Project Name: TOWN OF ATRISCO GRANT Unit(s) 8

RE: Project 1006761/13EPC-40103: Site Development Plan for Building Permit

DATE: May 8, 2013
TO: Jack Cloud, DRB Chair
FROM: Catalina Lehner, Senior Planner *CLL*
RE: Project #1006761, Lord Constructors/Kenworth Trucks
Zone Map Amendment and Site Development Plan for Building Permit

Staff reviewed the April 29, 2013 version of the site development plan for building permit and notes the following, minor issues:

SITE PLAN FOR BUILDING PERMIT

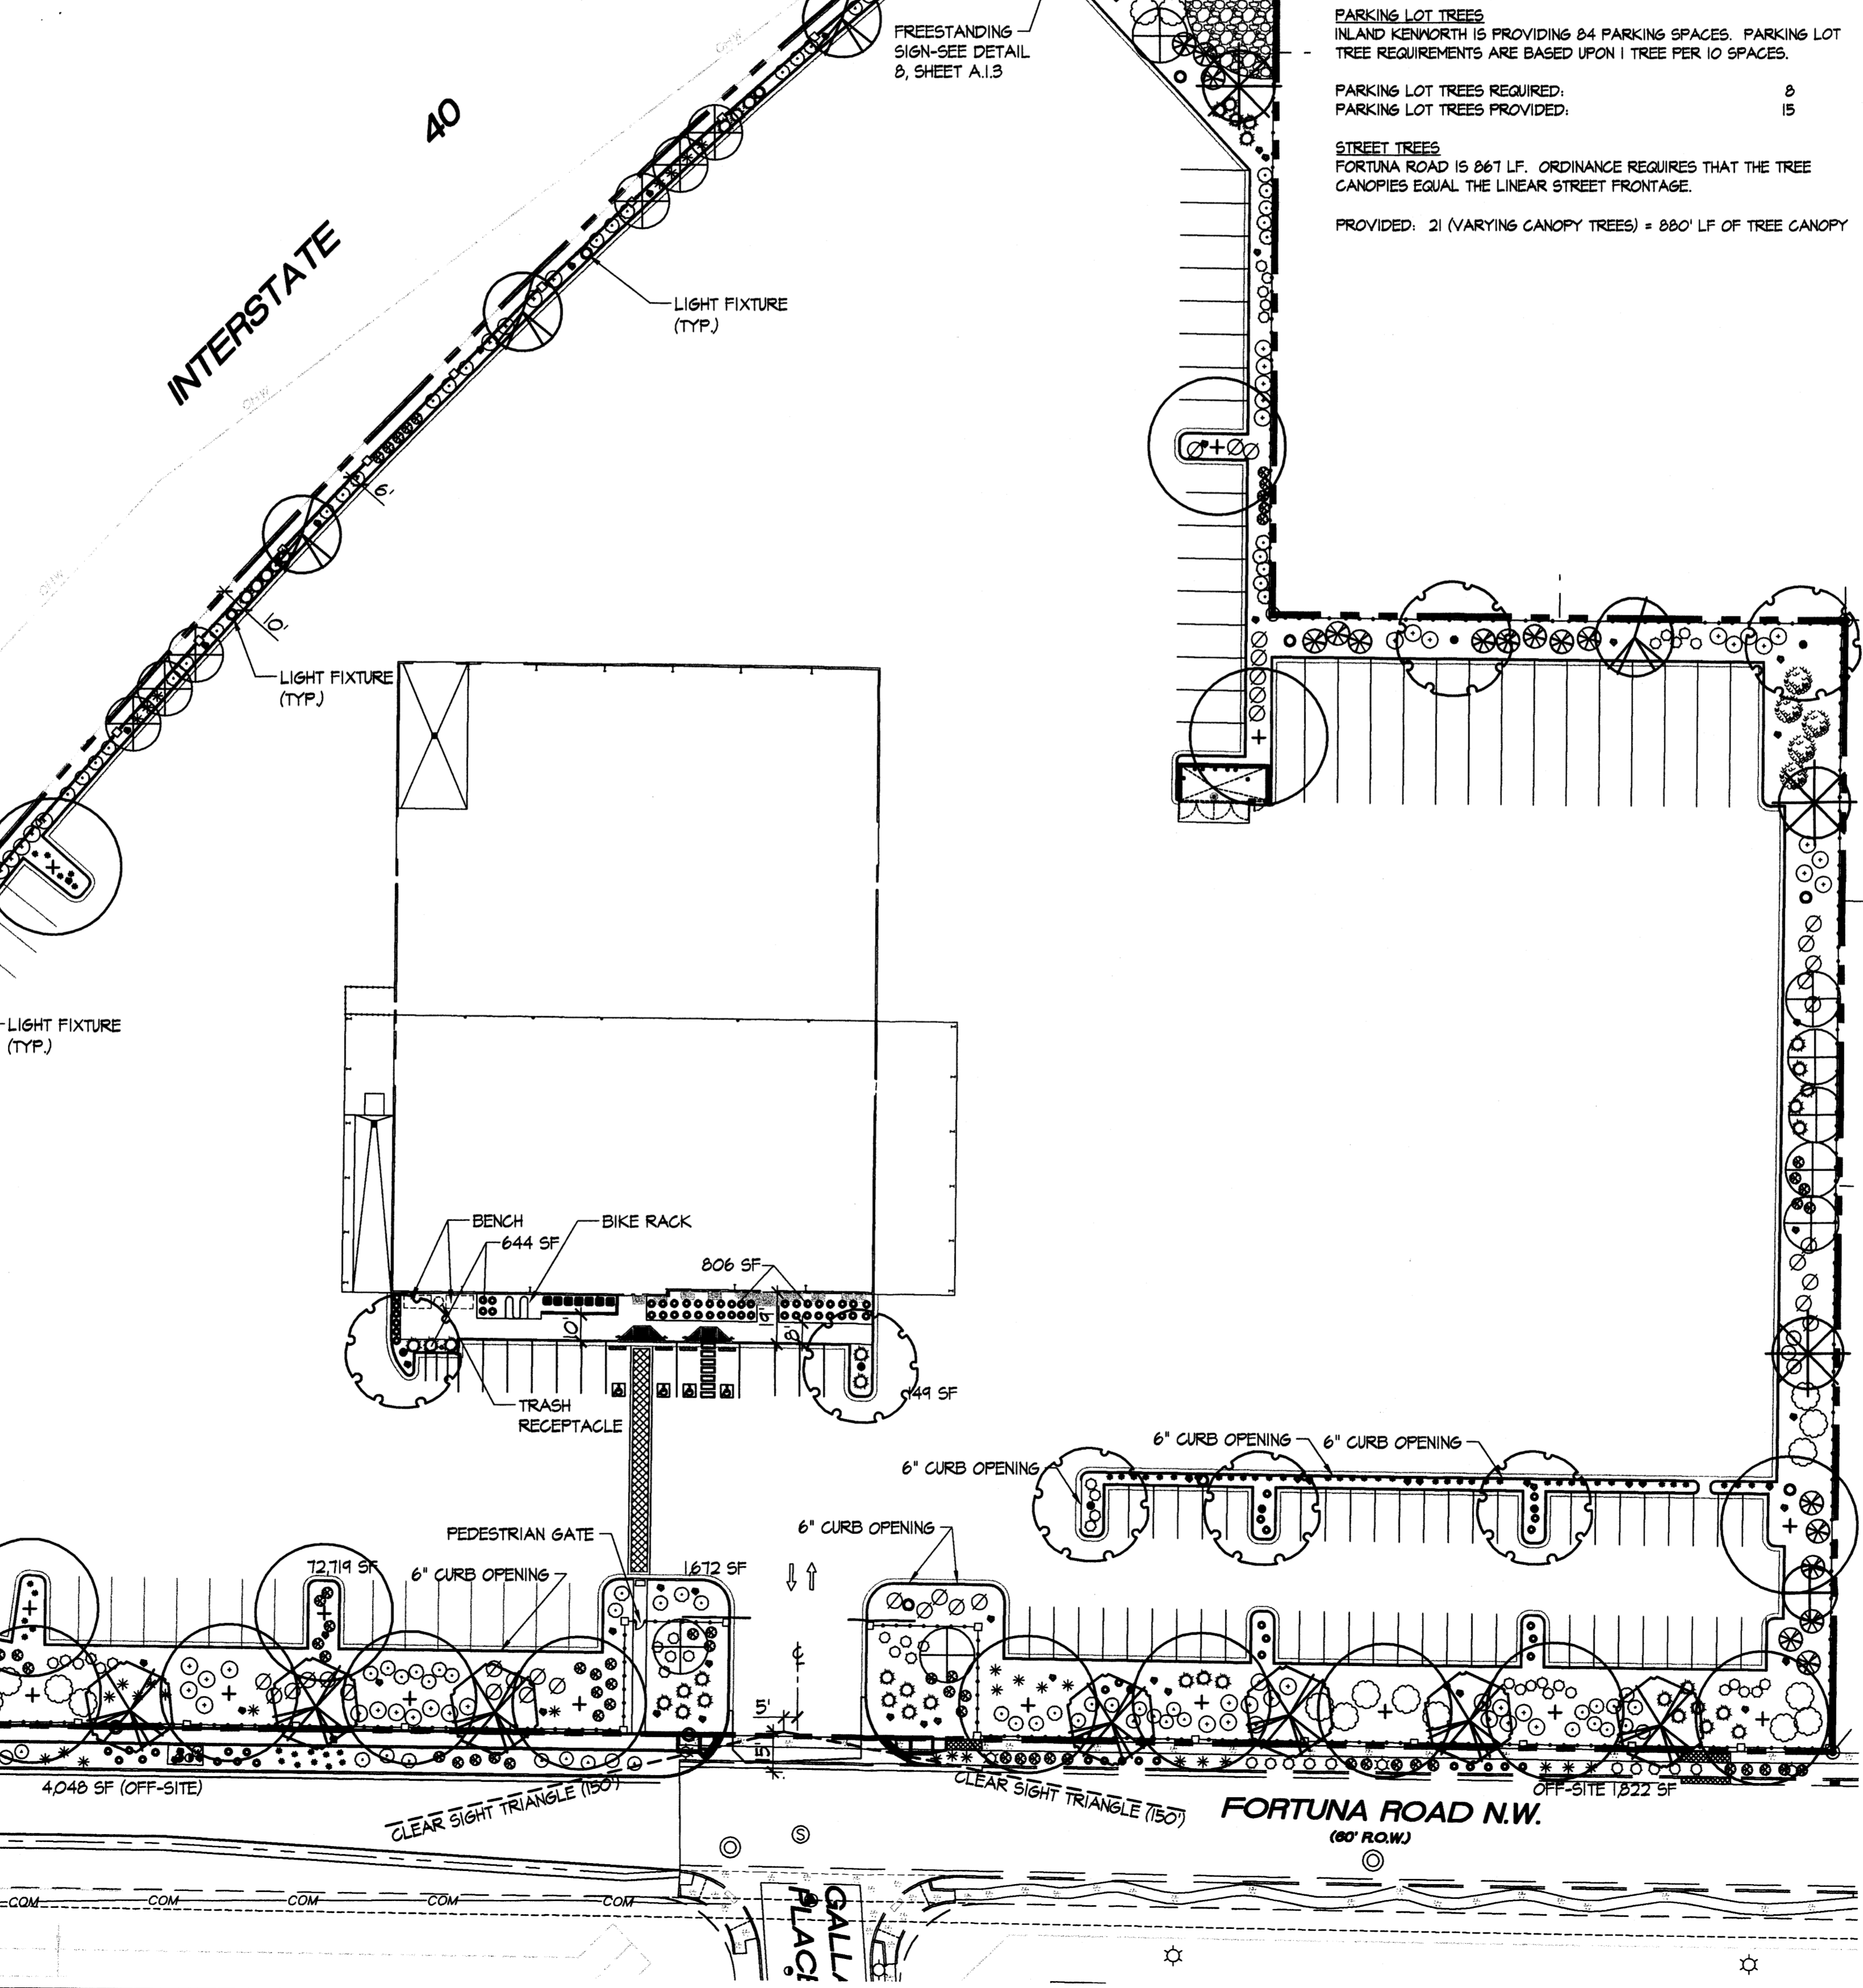
Condition 8B: I still get 5 feet when I scale it out on the main sheet and on the landscape plan, especially near the site's southeastern corner.

-
The landscaping buffer along the site's western side is a total of 10 feet wide and has been dimensioned

to show the easterly landscaped buffer as 6 feet wide and the westerly buffer as 4 feet wide.

11 WROUGHT IRON FENCE ELEVATION
NT5

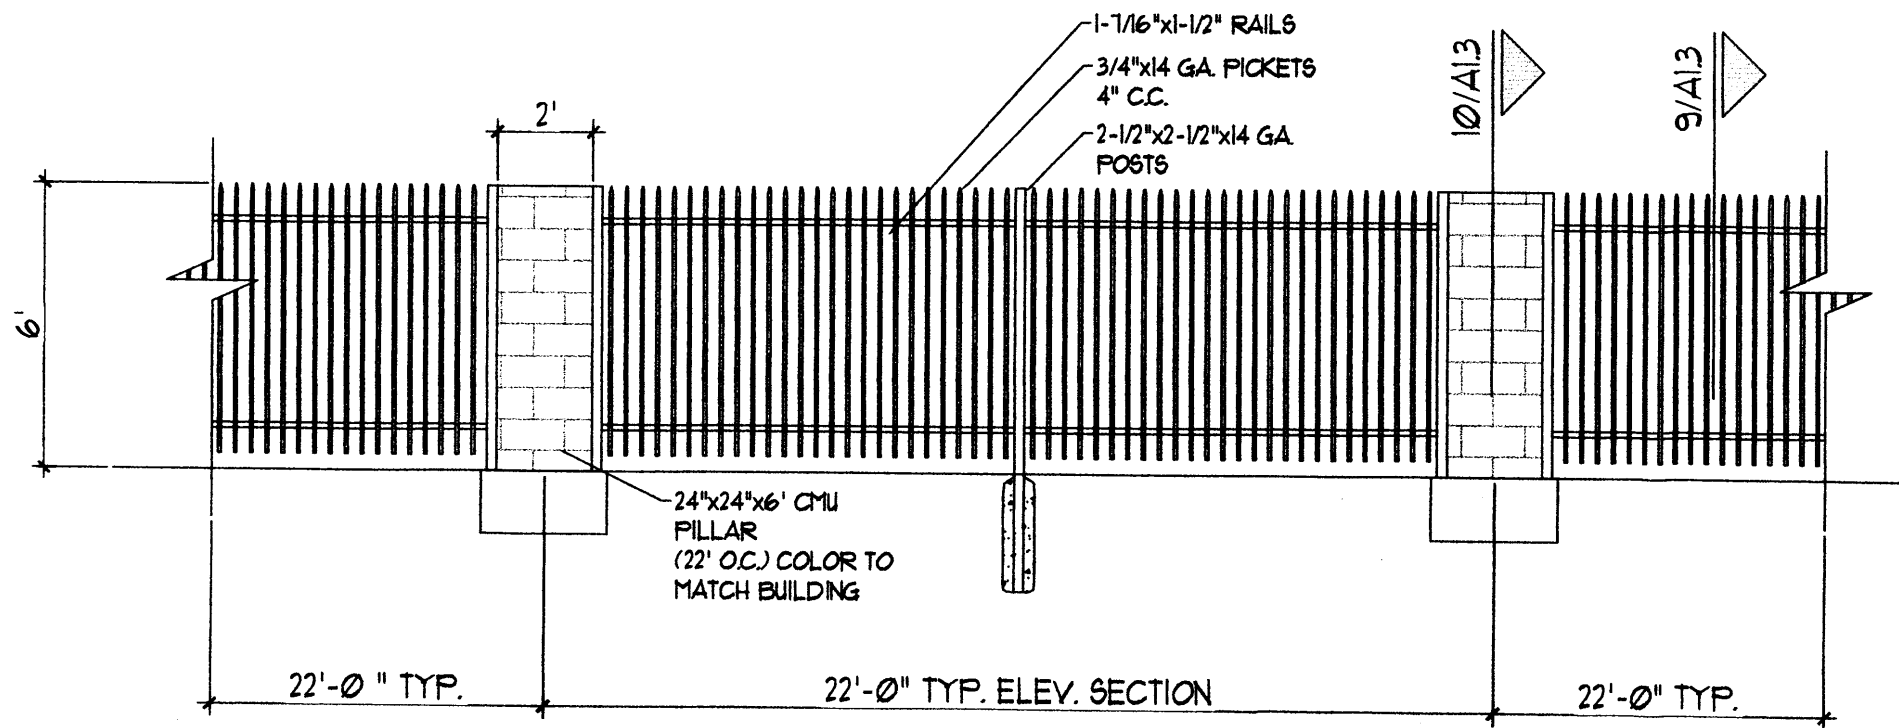
Condition 7A: On Sheet A1.3, the Wrought Iron Fence Detail doesn't specify the pilasters as grey (Sorry but I cannot find it).

The color of the pilasters has been specified to match the building, which is grey.

8 PROPOSED PYLON SIGN
SCALE: 1/4" = 1'-0"

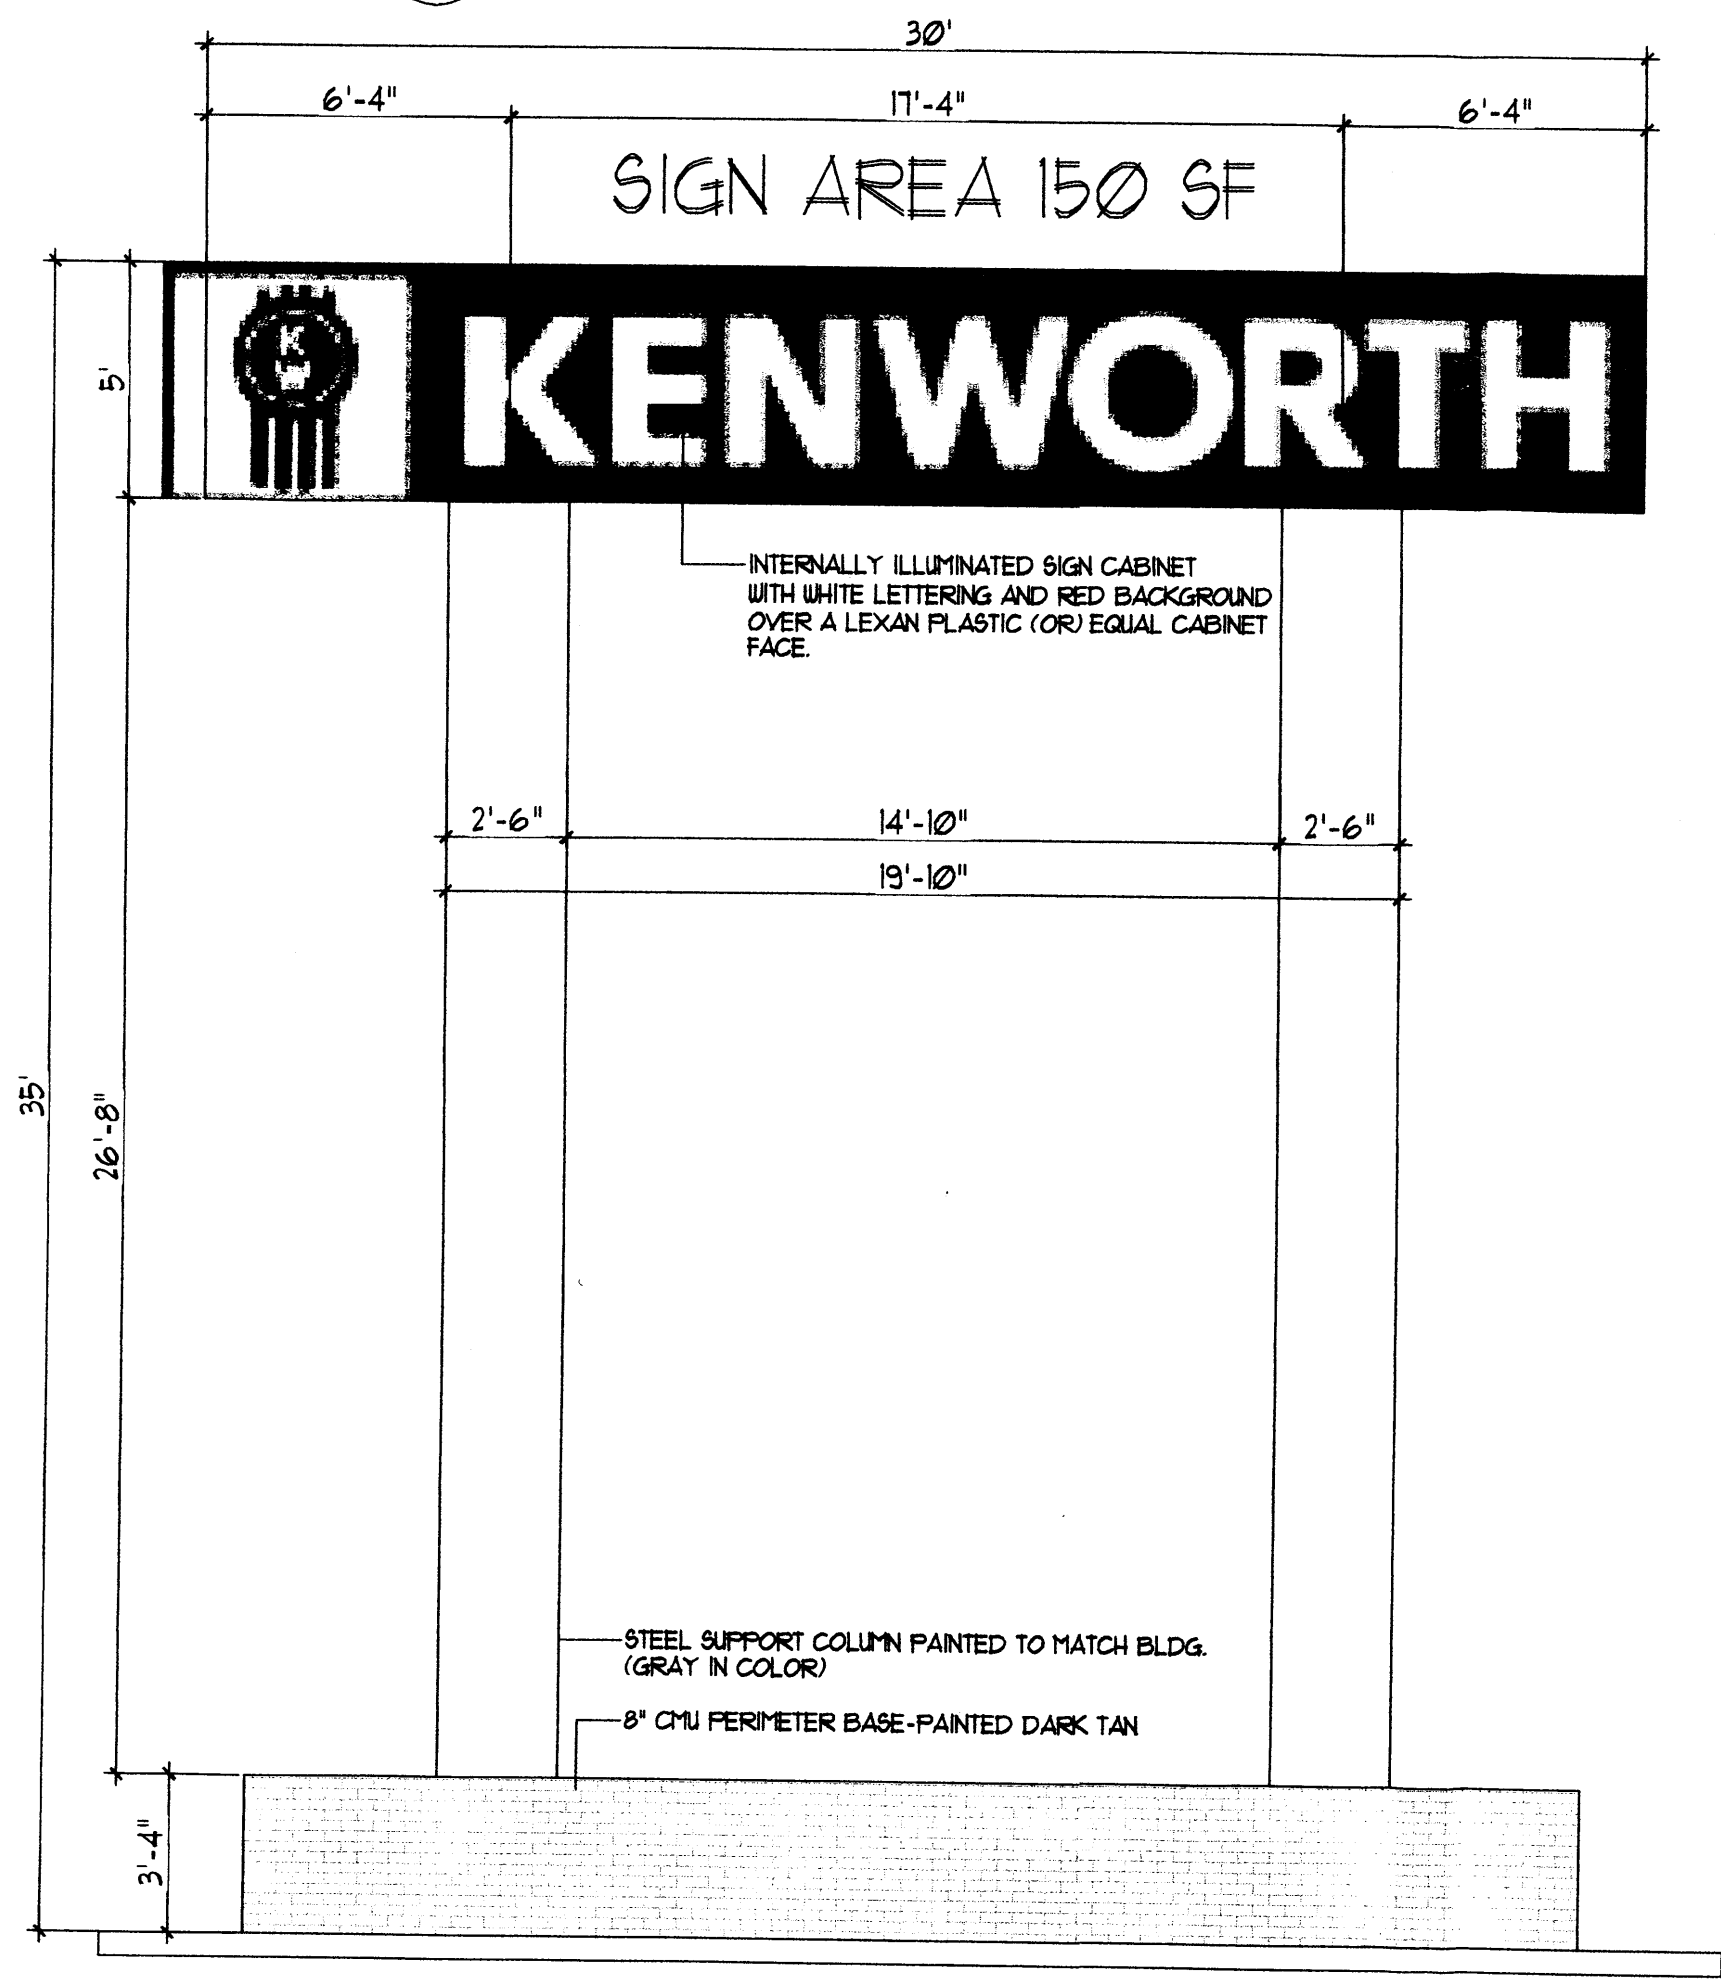
Condition 11: The scale on the free-standing sign appears to be incorrect. I apologize, but I cannot figure out what the correct scale would be to match the dimensions.

-
The scale on the sign detail has been corrected to 1/4"=1'.
